DEPARTMENT OF PLANNING AND DEVELOPMENT

May 5, 2004

Re: Lot 14 Carriage Lane (CBL 341 G006, 341 E001 & E0011)

Please be advised that the building permit application for the above referenced parcel, received on 5/4/04, must be denied for the following reasons:

Subdivision Plan	
CARRIAGE LANE	
Carriage Lane	
Portland, Maine	
MADE FOR	
Broadway Development	
Portland, Maine	
JOB# 99057	DATE: 06/24/99
BOOK# 678 & 658	SCALE: 1"=50'
DISC#	
FILE# 7908

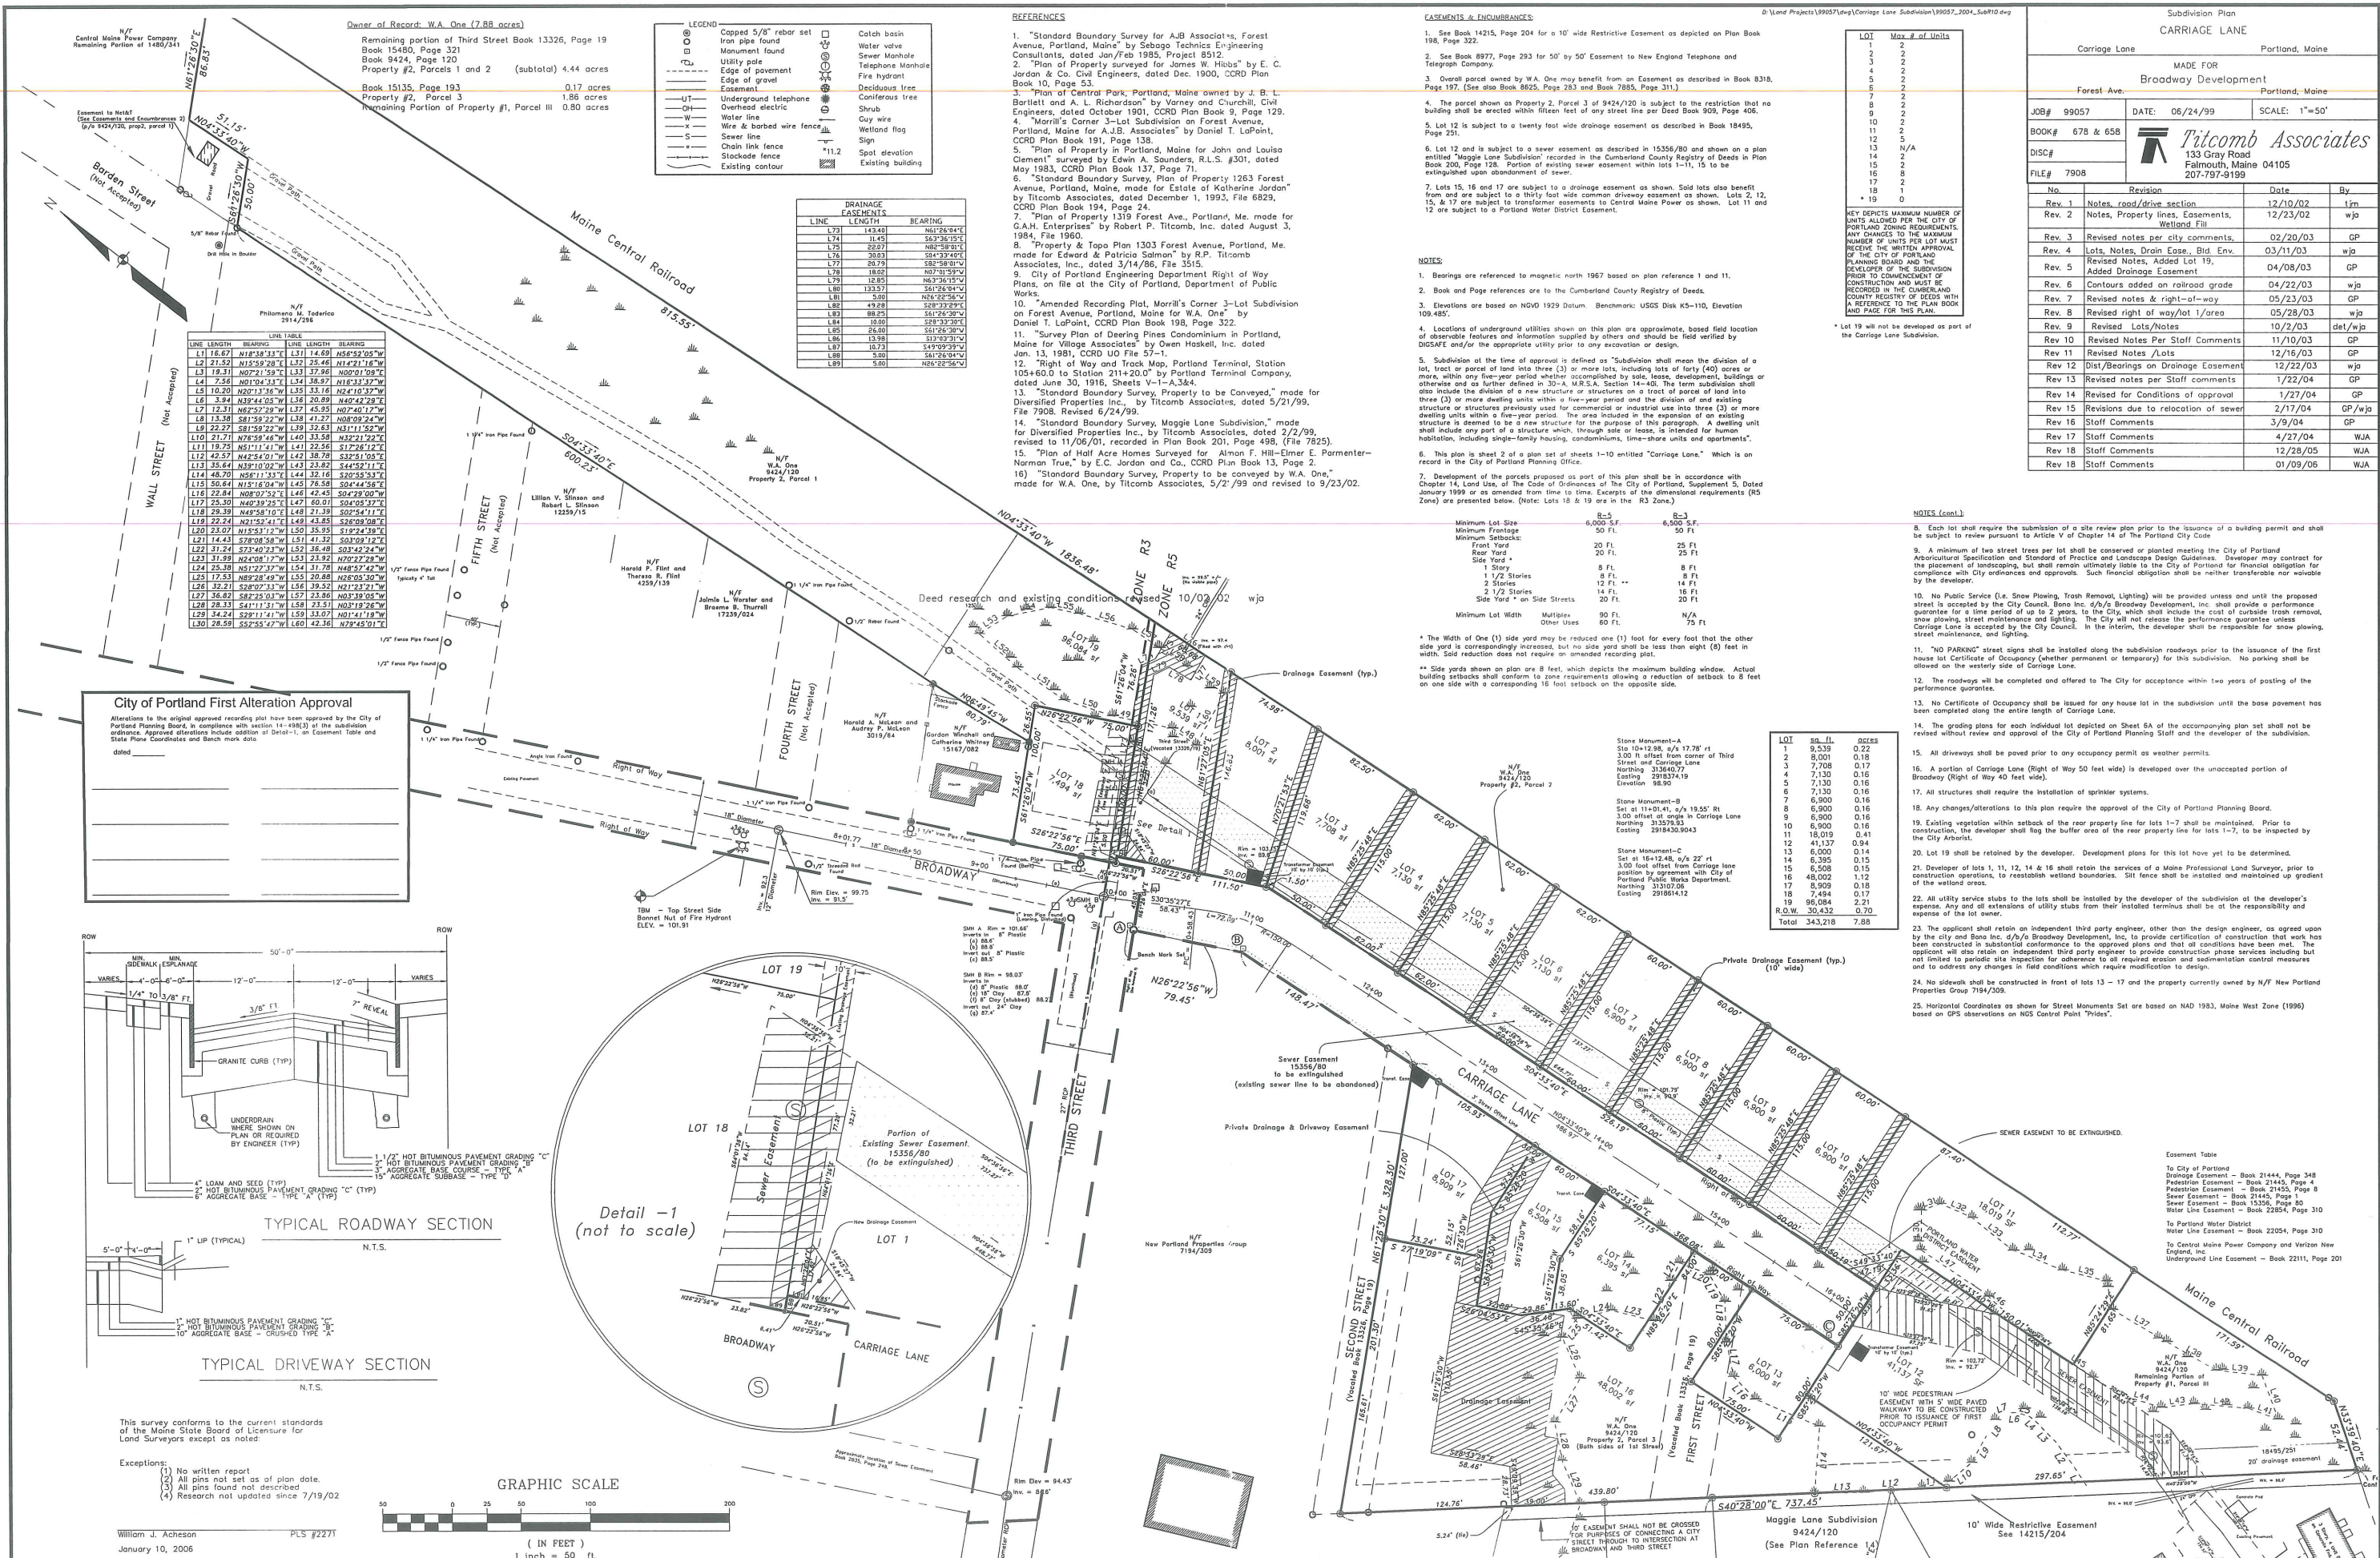
- 1) The applicant has not demonstrated right, title and interest for the lot in question. A recorded deed or valid purchase and sale agreement was not included in the application package.
- 2) The footprint of the building includes two bulkheads, which are not shown on the approved subdivision plan for lot 14. This proposed construction would appear to violate the required rear yard setbacks. The change in the footprint would also require a subdivision revision approval from the reviewing authority. Please see Section 14-461 and 14-464 of the Zoning Ordinance.
- 3) Pursuant to the Fee Schedule in the City Building Code, I have reviewed your proposed construction cost, which is apprx. \$59.00 per sq.ft. In looking at the 2003 RS Means Cost Book it appears to be under estimated. Please provide a specific cost analysis, including the sources of the quotes.
